Application: SSI 7485

I write regarding the proposed modification to M4-M5 Link, Mod 2 The Crescent overpass and changes to pedestrian infrastructure in North Annandale, Rozelle and Rozelle Bay Foreshore area.

**Figure 6 |** Indicative view of Rozelle Rail Yards pedestrian and cycling green link  
(Source: The Crescent Overpass Modification Report)

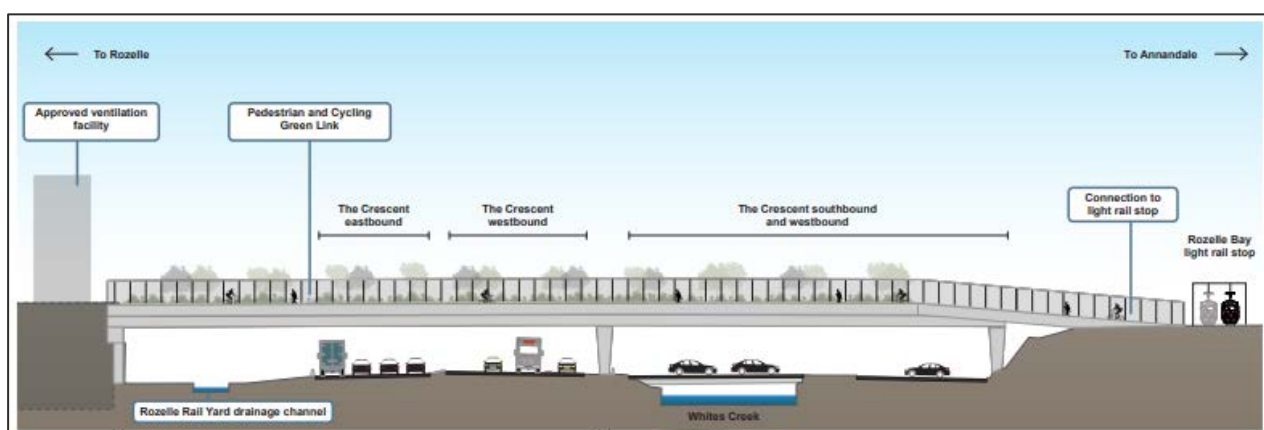
I request RMS work with the community to explore alternate design options to the proposed new car overpass design and the changed pedestrian and cyclist links. I am seeking the reinstatement of the safe, direct access from the approved EIS GreenLink to create a continuous green open space connection from the Rozelle Rail yards and Annandale to the foreshore. The GreenLink was more than just a walk way - it put people central to the design, maximising safety, and providing much needed accessible open space for the community now and into the future Bays Precinct design.

- Reinstate the GreenLink connecting communities and green open space from Rozelle to Bicentennial Park
- Relocate and design pedestrian and cyclist connections that are continuous, safe and direct.
- Design the modification infrastructure and active links in response to the character of the suburbs, the location of the foreshore and it's potential future development.
- Provide pedestrian and cyclist paths that maximise people safety and do not force them onto busier streets, unsafe concrete plazas and caged walkways.
- Integrate active and direct connections to all active transport – including the future Metro West and Foreshore Ferry Wharf

**Figure 10 |** Indicative pedestrian and cyclists crossing over The Crescent and Johnston Street  
(Source: Response to submissions on Design Amendment Report)

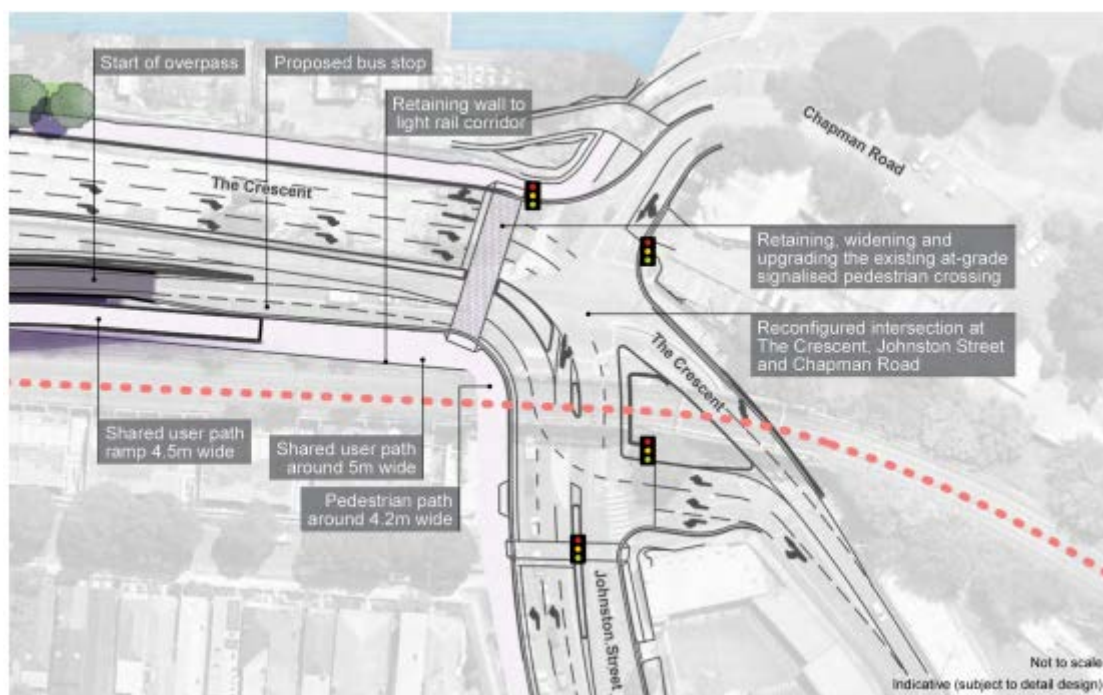
- The significantly reduced safety and increased risk for pedestrians and cyclists with removed access over The Crescent to Bicentennial Park and the increased traffic along Johnson Street.
- Being required to cross five sets of pedestrian lights at The Crescent as my option to reach the foreshore from Annandale or from Rozelle Bay light rail stop.
- Removal of direct active links to the foreshore, cutting the community off from the area and the proposed revitalisation of the entire Bays Precinct, including linking the Light Rail and Bus stops to a Ferry wharf and Metro station.
- Urban and landscape design that is being built before a finalised Masterplan for the area.
- Traffic changes that limit movements around the suburb and create further congestion in the local streets of Annandale, Forest Lodge, Glebe, Lilyfield and Rozelle with no planning to deal with these.
